BL-14-00022 East of Douglas Curry
Current line: 104636

Subject: Curry Boundary Line Adjustment (BL-14-00022)

Re: Estate of Douglas D. Curry
Application for Boundary Line Adjustment
Parcels #145734, #104636
3032 Upper Peoh Point Road and 3030 Upper Peoh Point Road

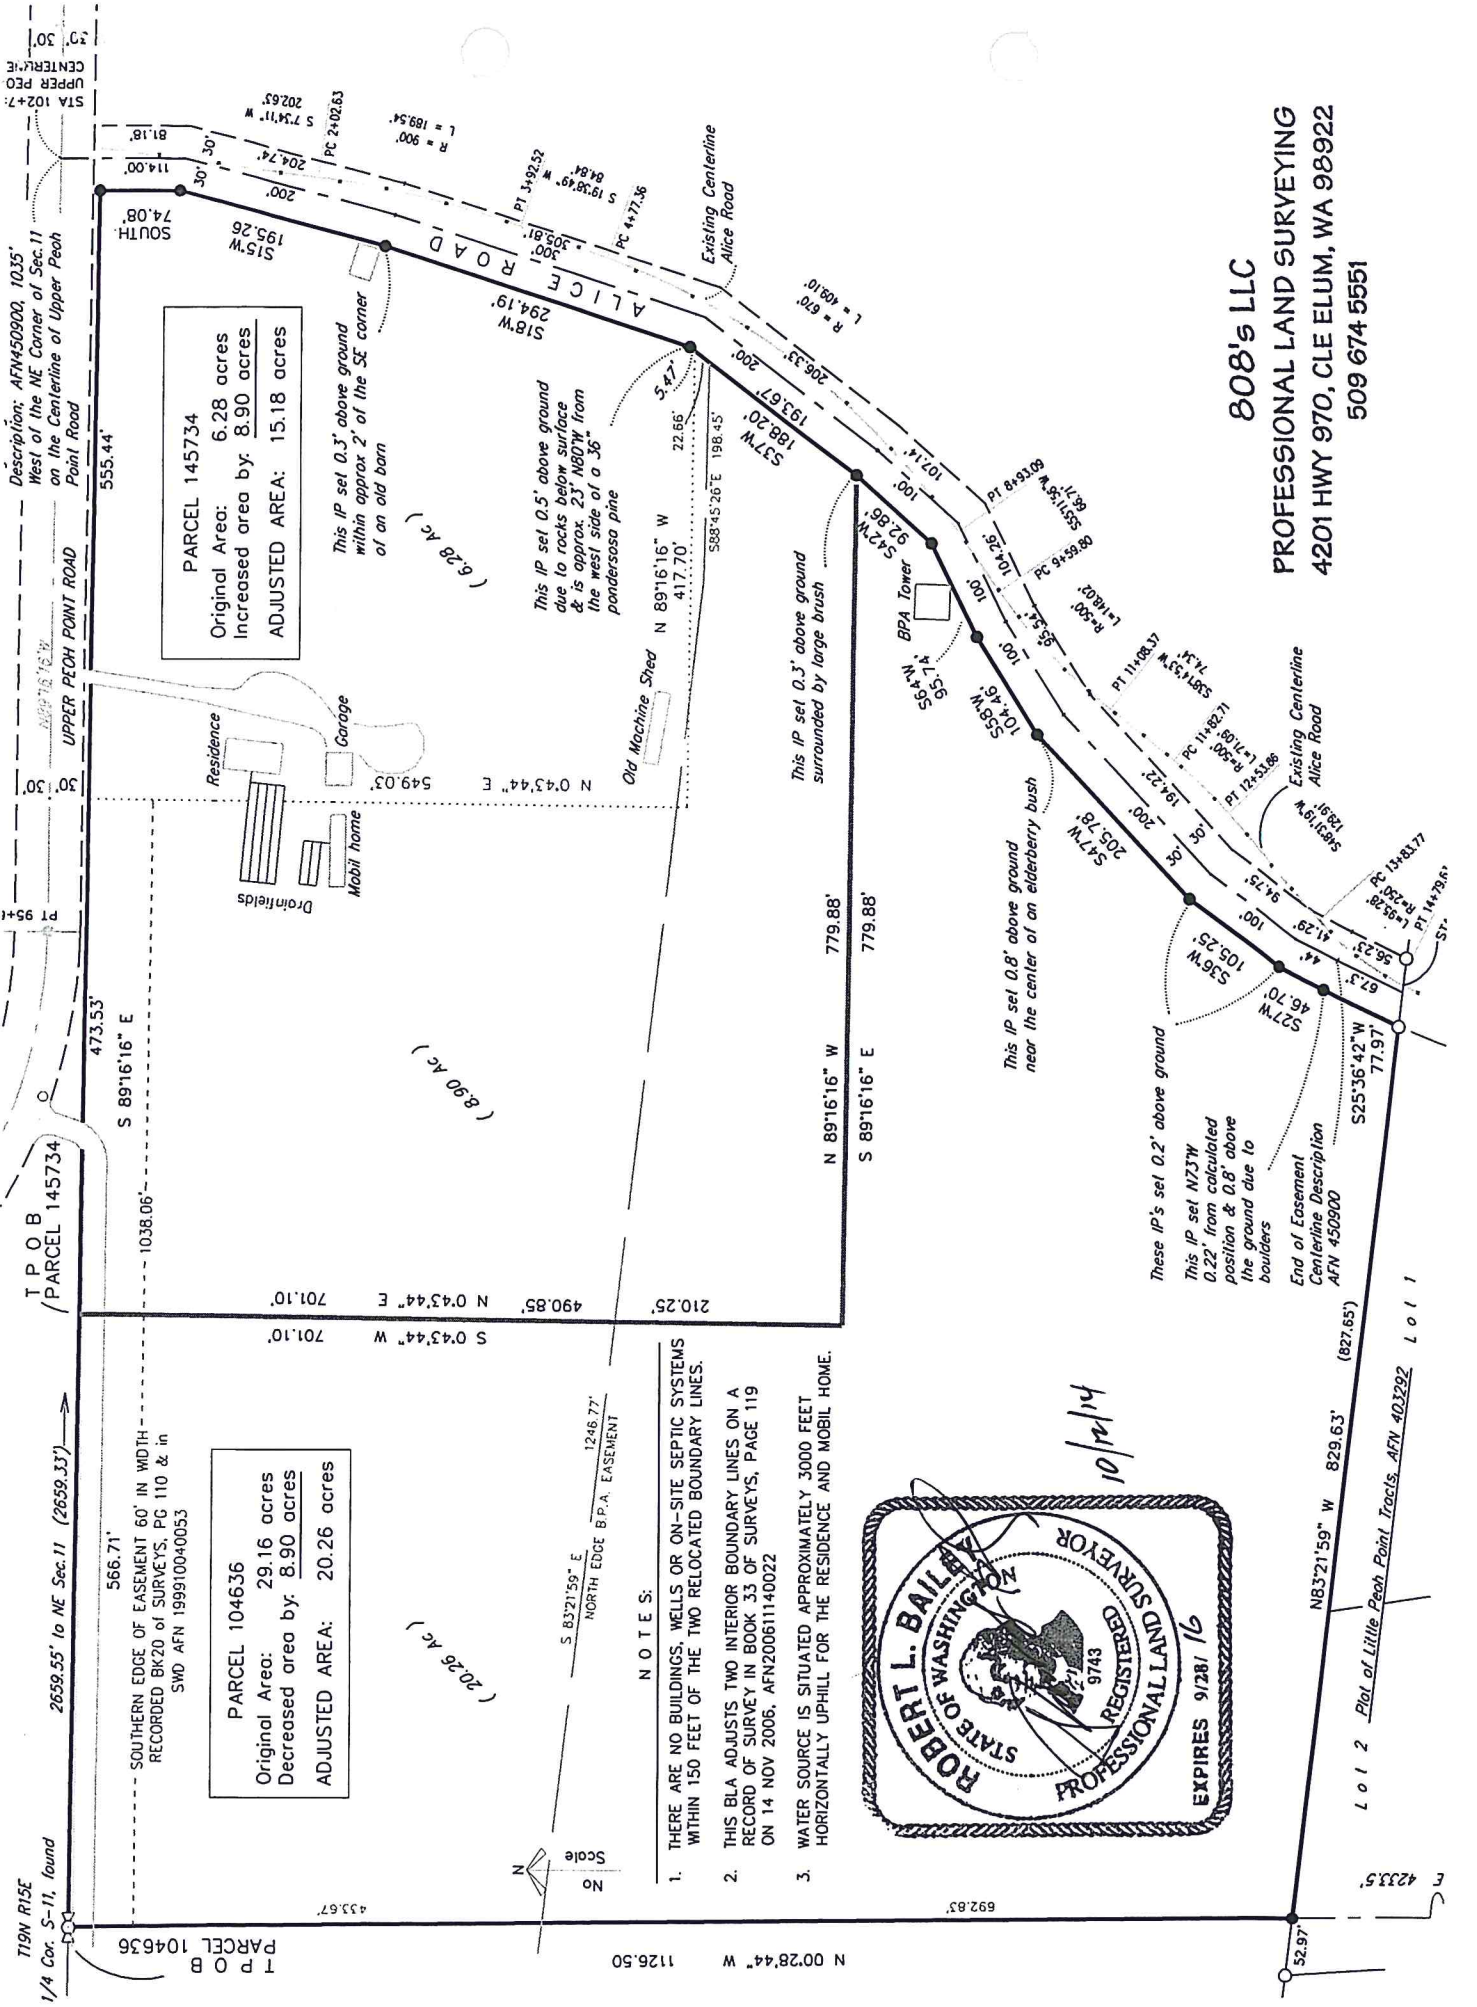
The only thing I don't see is the location of any well on either parcel. Otherwise these will work fine.

- ***Location of Septic and Wells on all parcels associated with Boundary Line Adjustment on an existing site plan.***

1. There are no wells on either of the parcels owned by the Curry estate for which a boundary line adjustment is requested;
2. The septic system drainfields are clearly delineated on the survey map drawn by Mr. Bailey that was submitted with the original application. I attach a copy for your ease of reference; please see page 8 of the application for the referenced map. As you will see, the septic system/drainfields are located immediately west of the residence and north of the structure labeled "mobil home."
 - a. Note 1 of Mr. Bailey's notes on the map reflect that no wells or septic systems are located within 150 feet of the adjusted boundary lines.
 - b. Note 3 of Mr. Bailey's notes on the map describes the location of the water source for the property

There is no well on either property. Mr. Bailey also made a note of that on his drawing. The primary source of water for the house is from a spring on a property south & slightly east of these properties. Access is protected through an easement supporting access for purposes of the water right.

BL 14-00022  
 Current line: 104636  
 Est of Douglas Curry

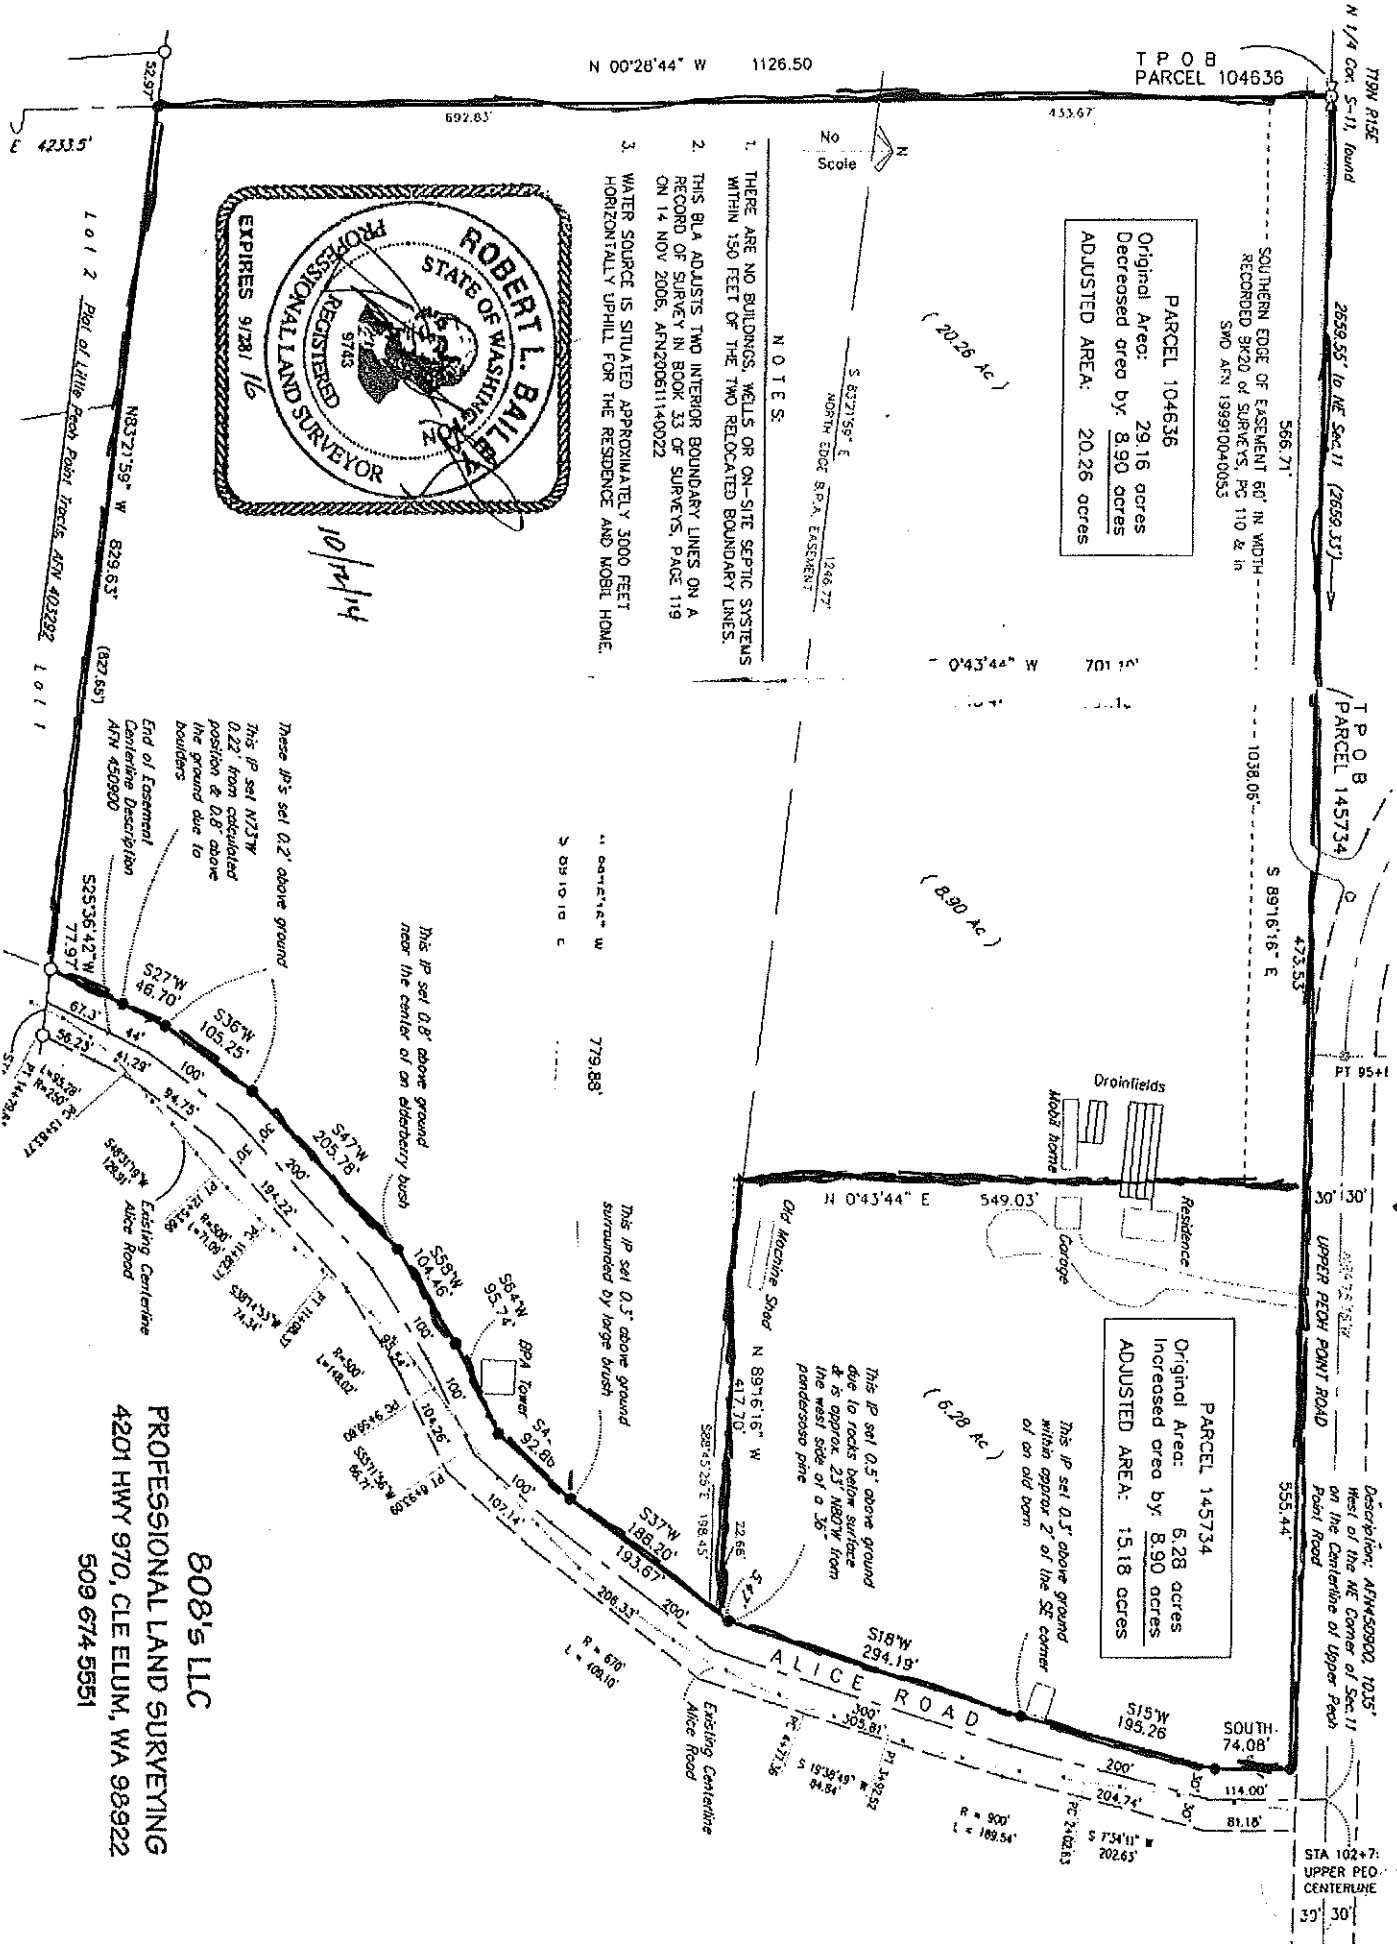
The additional information letter is in regard to the fact that you did not submit a site plan showing the *existing* configurations of the subject parcels. You did submit a site plan of the *proposed* configuration of the parcels, but as it states directly on the BLA application a site plan of the existing parcels/ lot lines needs to be submitted for a complete application.

Dear Ms. Hathaway, I attach a revision to the site plan submitted with our existing application reflecting the current boundary lines. This revision should supplement the plan reflecting the boundary lines as to be adjusted.

Good afternoon Ms Hathaway, my understanding of your original email attaching the letter was that the information that you were requesting was the location of wells and septic systems, so I addressed those issues under my response. But your subsequent voicemail identified that you want a site plan of the existing lot lines. Both of these lines are depicted on the map submitted with our application on page 8. The existing lot lines are depicted with a broken line and the proposed lot line is depicted with a solid line. The proposed lot line runs from north to south on the submitted map and makes a right angle running from west to east.

The existing line also runs from north to south as a dotted line (you will see it running through the eastern portion of the drainfields just west of the residence.)

The existing line then turns to the east as depicted by the dotted line immediately south of the structure labeled "the old machine shed."
